## **Development Facilitation Team (DFT) – Review Comments**

**Project No: PR-2020-004596      Date: 03/27/2024      Agenda Item: #3 Zone Atlas Page: D-10**

**Request: PRELIMINARY PLAT EXTENSION FOR 30 ACRE DEVELOPMENT TO INCLUDE 162 TOWNHOME LOTS, 1 MULTI FAMILY RESIDENTIAL LOT WITH 175 APARTMENT UNITS AND 1 COMMERCIAL LOT WITH A TOTAL OF APPROXIMATELY 21, 955 SQUARE FEET OF BUILDING SPACE. PRELIMINARY PLAT ORIGINALLY APPROVED MARCH 29, 2023 BY THE DRB.**

**Application For: SD-2024-00045-EXTENSION OF PRELIMINARY PLAT (DHO)**

SEE SHEET 4
 MATCHLINE

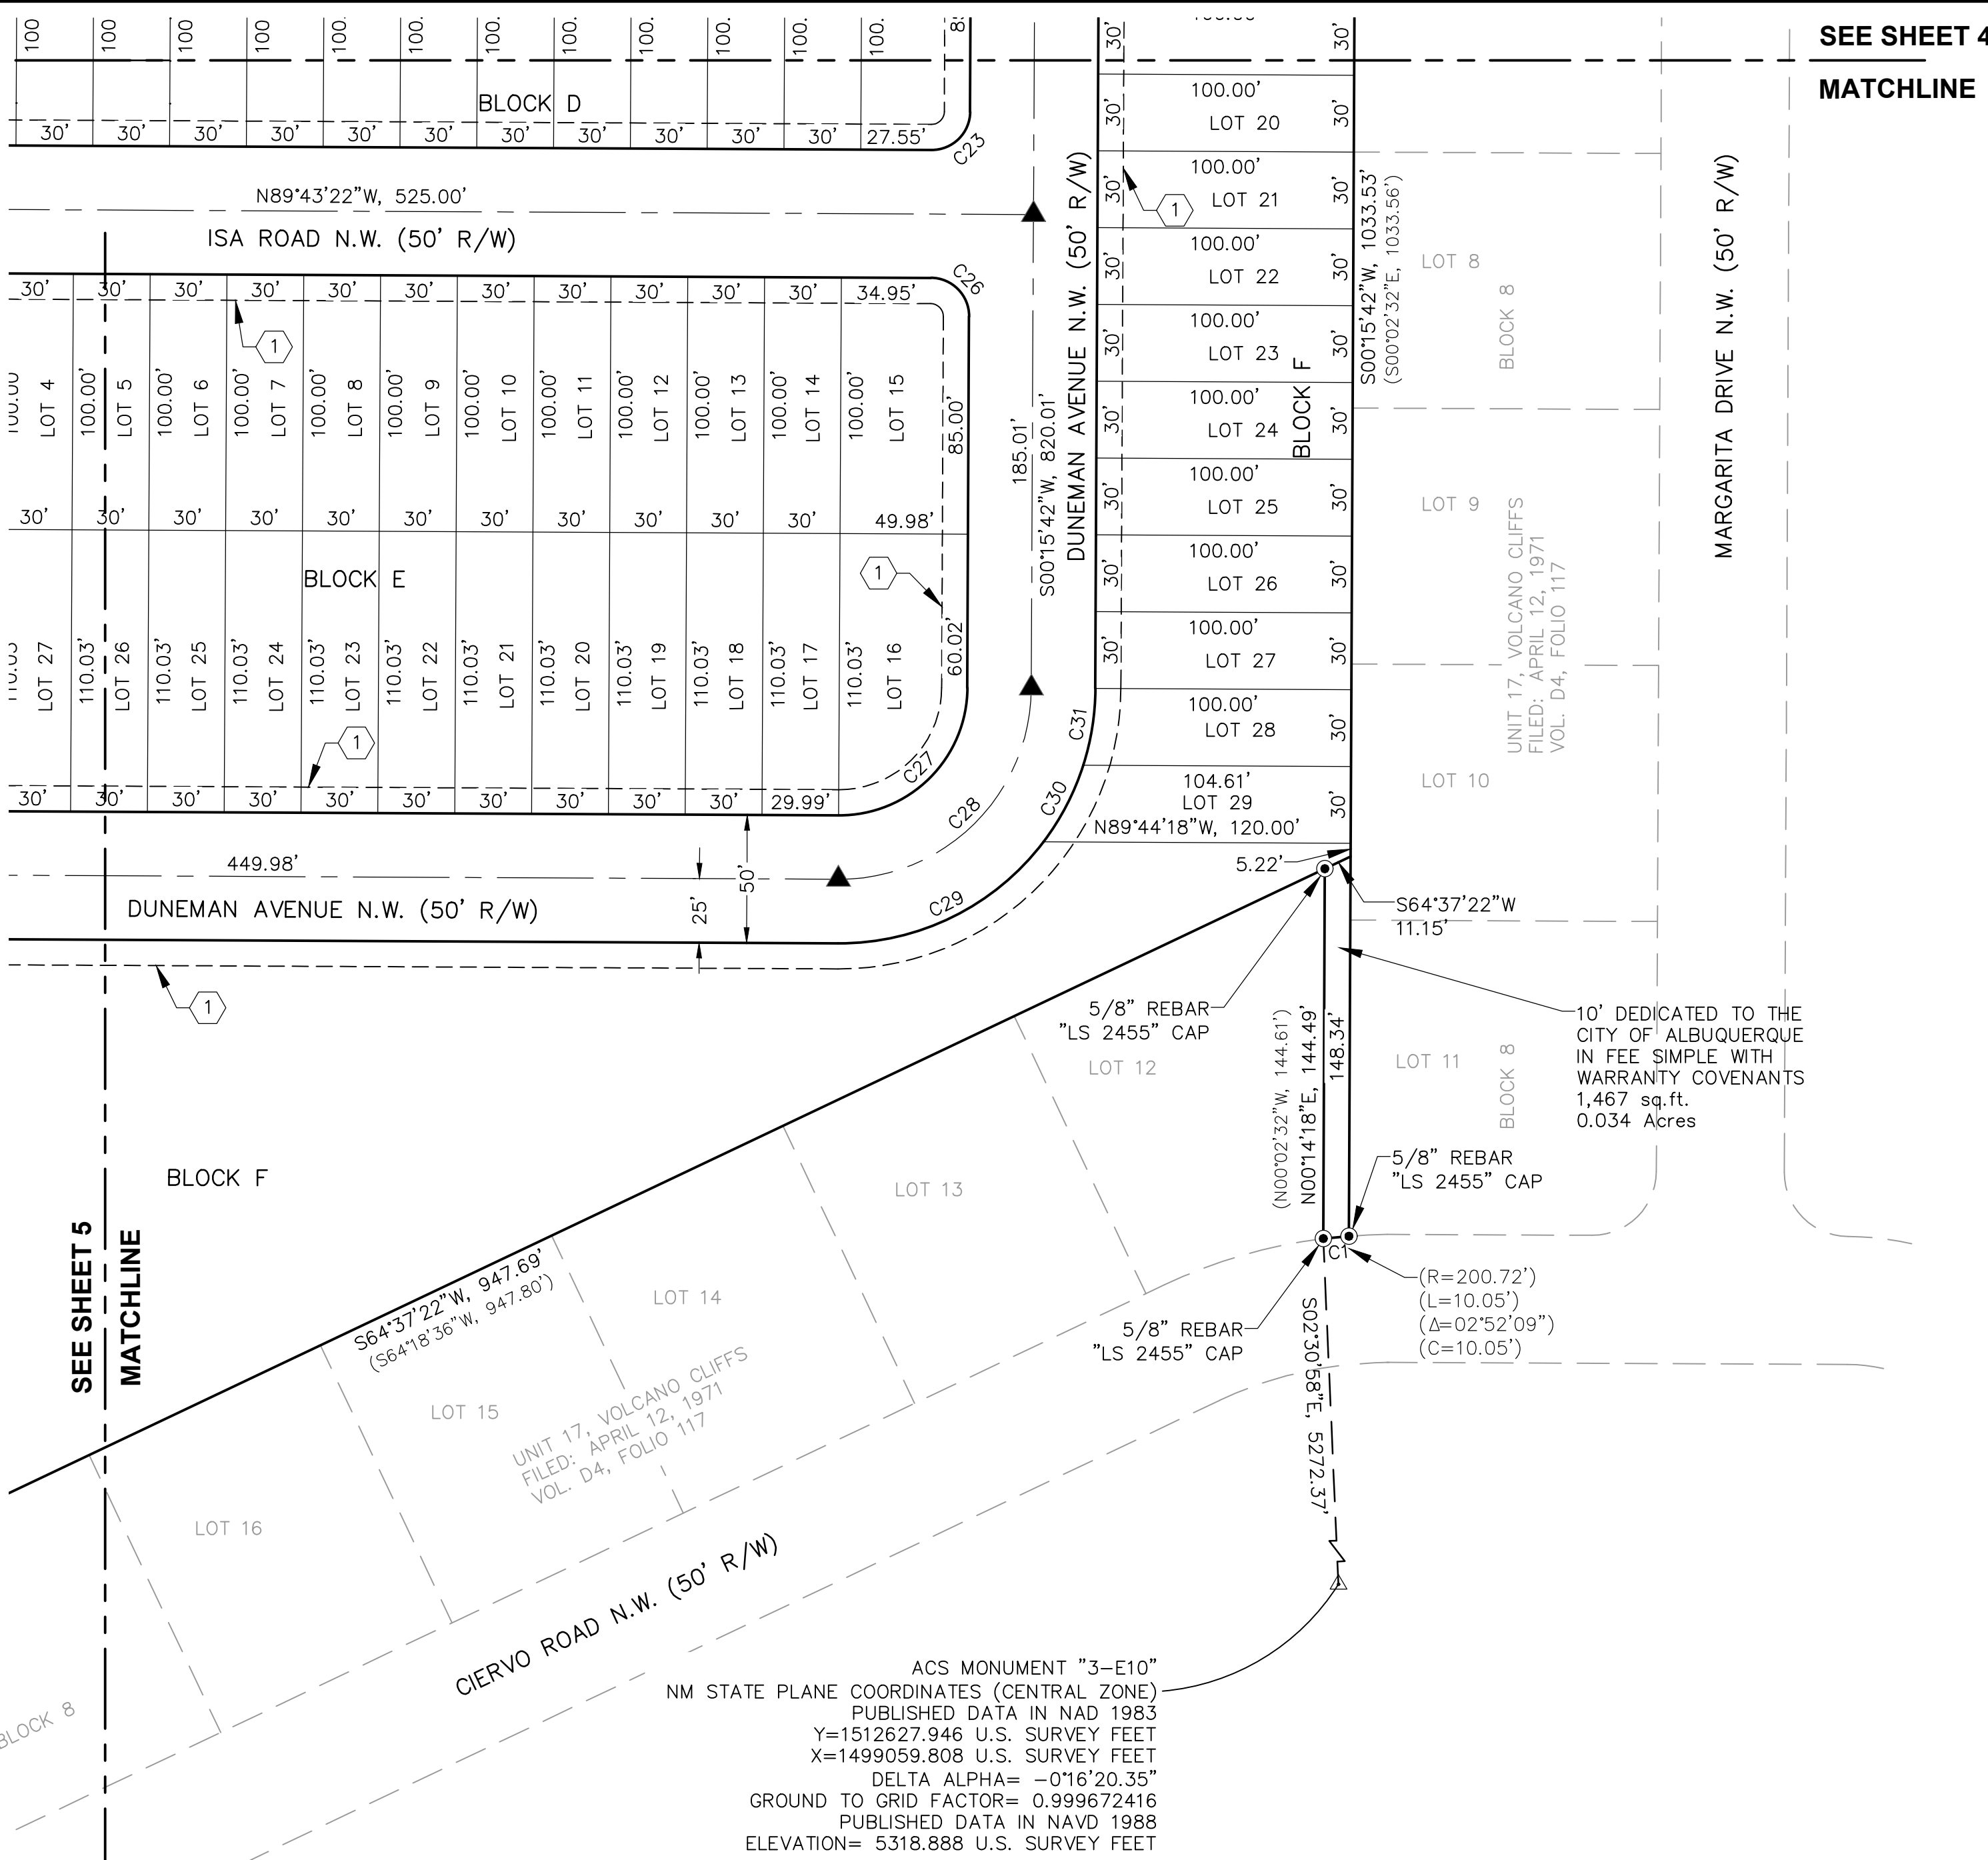
3. **Development** standards of CPO-13 include Façade Design, Building Design, and Garage access limitations (*including rear-load access for townhomes*). It is not clear in this plan that this has been accounted for – please clarify how townhome units in this plan would be accessed.

**Table 5-4-1 limits block lengths on local streets to 600 feet. Block 'F' townhomes is greater than 600 feet. Lots 4 thru 31 create a block greater than 600 feet.**

**5-4(F)(2)(b) Residential lots shall avoid layouts where the rear lot line is adjacent to a collector or arterial street.** Local frontage roads may be used within a subdivision to avoid locating residential rear yard walls along collector and arterial streets. **In the layout presented, rear lot lines are on local streets.**

ROAD SECTION @ PEREZOSO DRIVE NW (LOCAL STREET) A2
 SCALE: 1"=10'

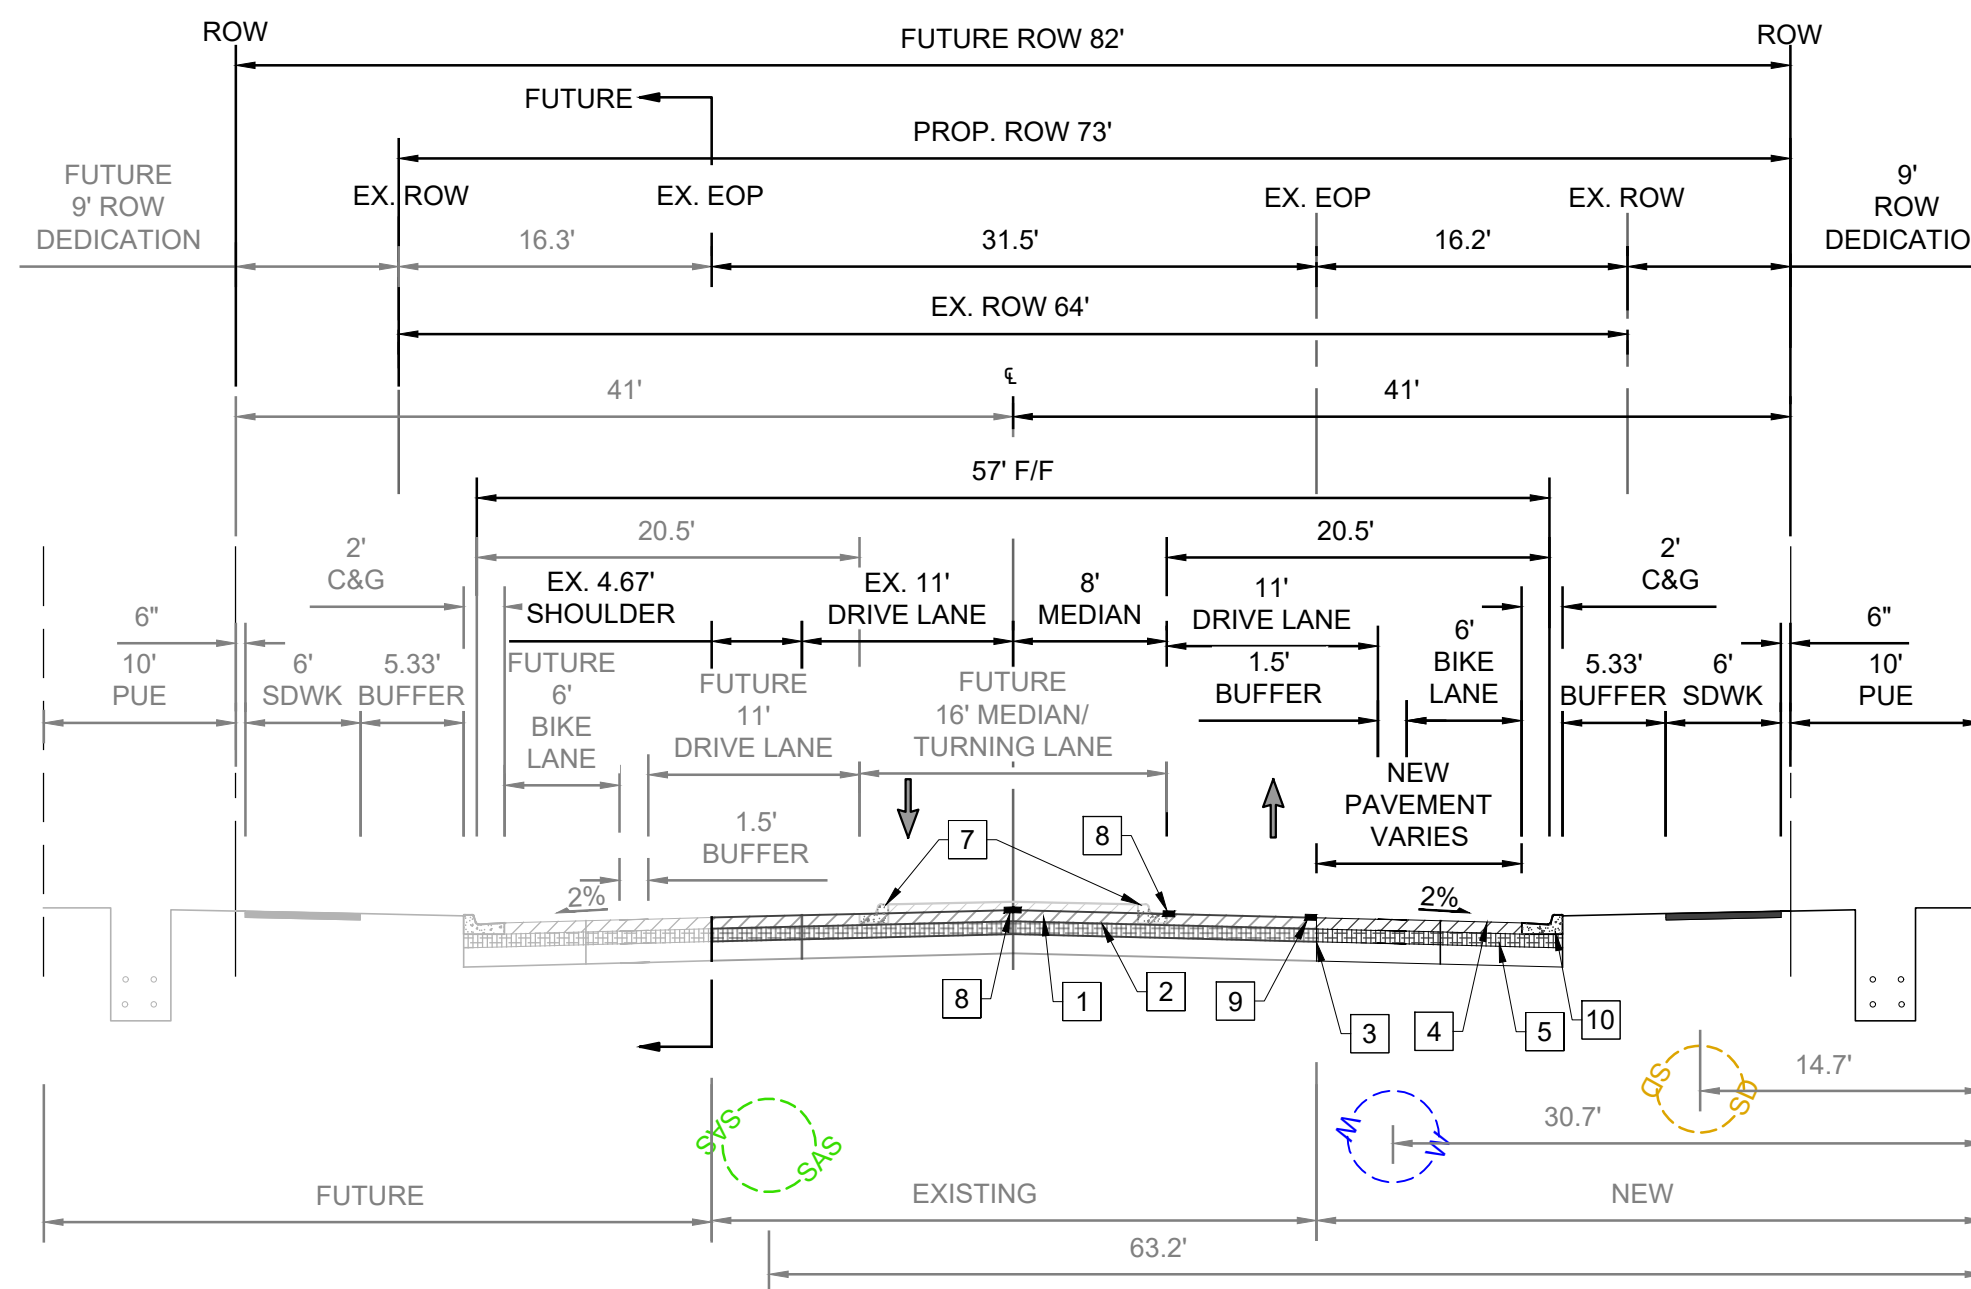
5. Street Cross Sections: IDO 3-4(N)(5)(e), CPO-13 states: “Development within the Volcano Mesa – CPO-13 shall comply with all requirements in the DPM related to transportation design standards, including but not limited to street cross sections.”

4. Street Cross Sections: IDO 3-4(N)(5)(e), CPO-13 states: “Development within the Volcano Mesa – CPO-13 shall comply with all requirements in the DPM related to transportation design standards, including but not limited to street cross sections.”
